**WEST SUSSEX COUNTY COUNCIL
INFRASTRUCTURE CONSULTATION**

SUBJECT: FP/225/08

10 South Road, Felpham

Construction of 2x3-bed chalet bungalows to rear to 10 South Road

SITE PLAN 1:500

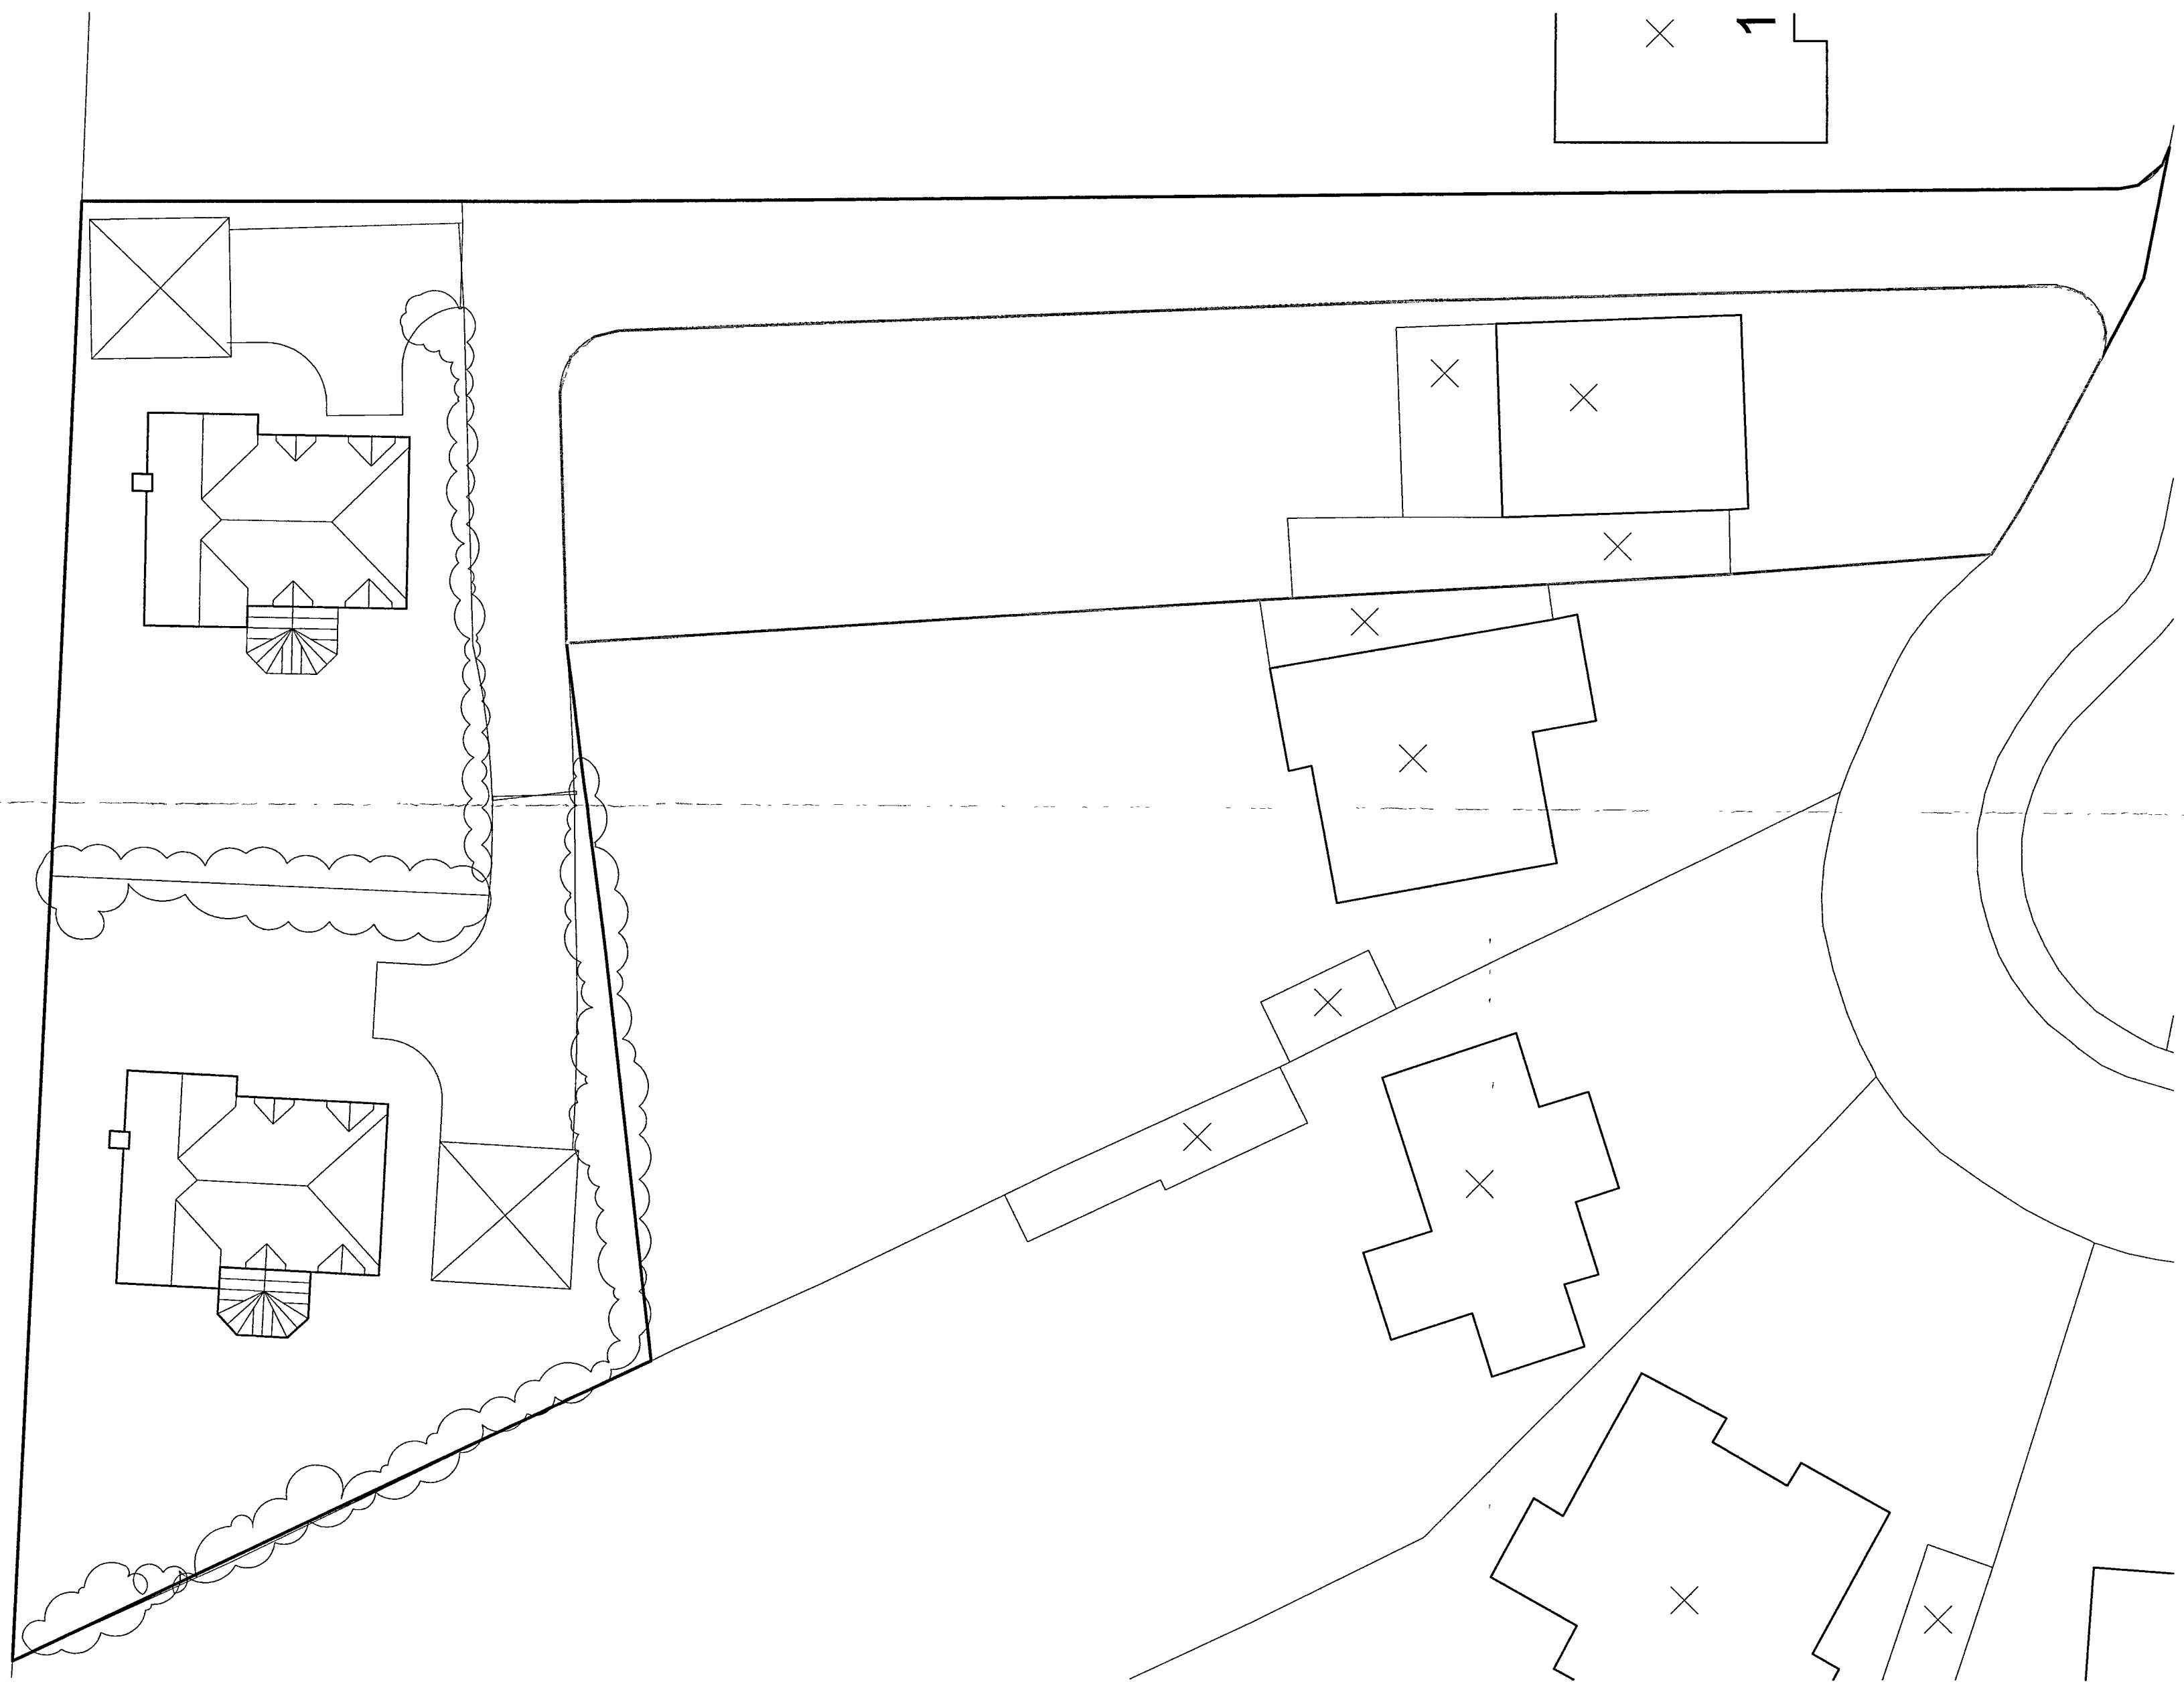
The proposal is for the construction of 2x3-bed bungalows with access onto South Road via a new access point. From an inspection of the plans alone, there is no apparent visibility issue at the point of access onto South Road, and the most recently available verified accident records reveal there have been no personal injury accidents in the vicinity of the existing point of access, indicating a low risk of highway safety issues with this proposal.

However, the applicant has still not demonstrated that service vehicles could access the proposed properties and turn to leave in a forward gear. More information would therefore be required in order for this application to gain approval, and this should take the form of a diagram showing the turning path for a large vehicle.
